BICESTERBUG

Comments on Bloombridge Ltd's Design for Cycle Users at Phase 1B,
Bicester
Cherwell Planning Reference: 20/00293/OUT
Version 1.0
25 June 2020
Paul Troop

Figure 11: Indicative Masterplan

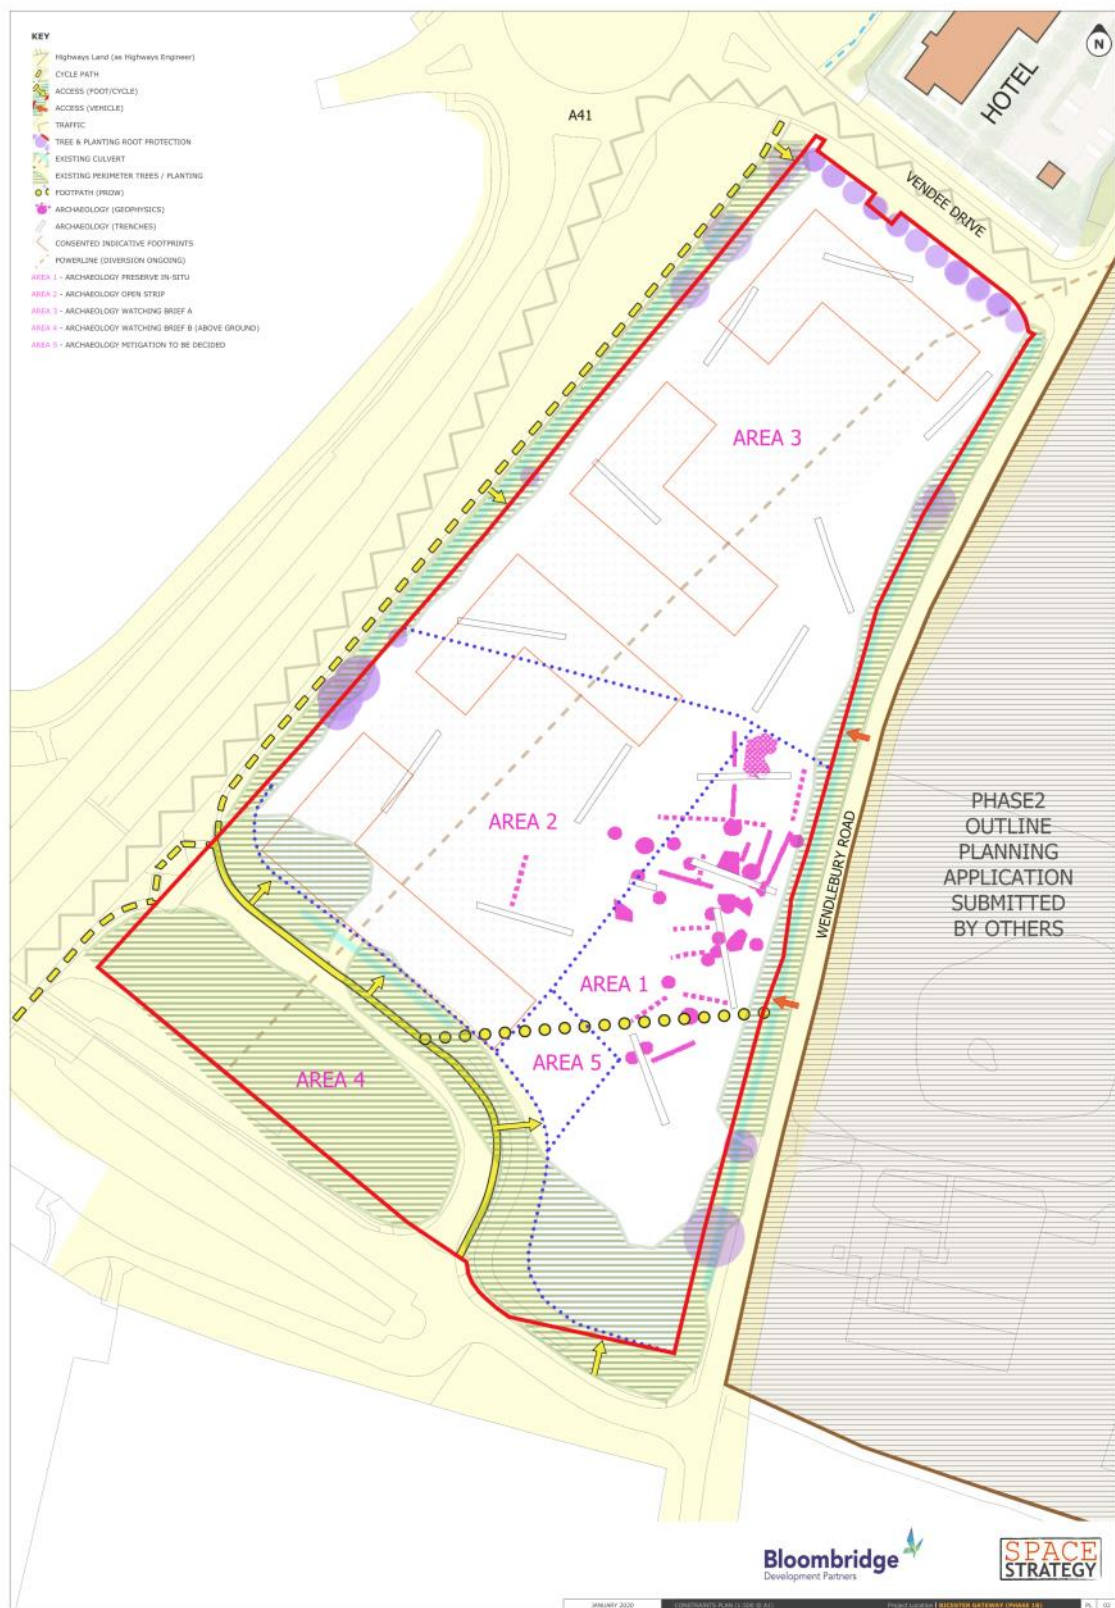
Insufficient attention has been paid to Charles Shouler Way. Bloombridge's indicative masterplan shows pedestrian only use of the northern side of Charles Shouler Way and no pedestrian or cycle use of the southern side. This does not appear to be in accordance with OCC's Cycle Design Standards or the relevant provisions of the Cherwell Local Plan. Stepped cycle tracks (2.2.6) or segregated cycle lanes (2.2.8) should be provided. If space is constrained, a shared cycle and pedestrian path may be acceptable (3.4.8).

There is no pedestrian or cycle provision whatsoever presently envisaged on the south side of Charles Shouler Way. This seems a significant omission given that the south side of Charles Shouler Way is likely to be the preferred route for many residents of Phase 1B and visitors approaching via the A41 shared path and Chesterton sliproad to the now committed Phase 2 development.

There is still no straightforward route for a cyclist approaching from the frontage of Phase 1B along the Wendlebury Road to access the facilities at Phase 1A (including the shared path along the frontage of Phase 1A along the Wendlebury Road). The developer's indicative masterplan still shows use of a pedestrian only route across the Wendlebury Road end of Charles Shouler Way. This will encourage such cyclists to either break the law by cycling on a pedestrian only link, or instead to try to navigate a very contorted route to Phase 1A. As such, the current plan does not maximise cycle connections between different areas of Bicester 10 as required by the Cherwell Local Plan. It would make much more sense to provide a shared cycle link at this point with a refuge so that vulnerable cyclists can cross the road using an uncontrolled crossing in two movements.
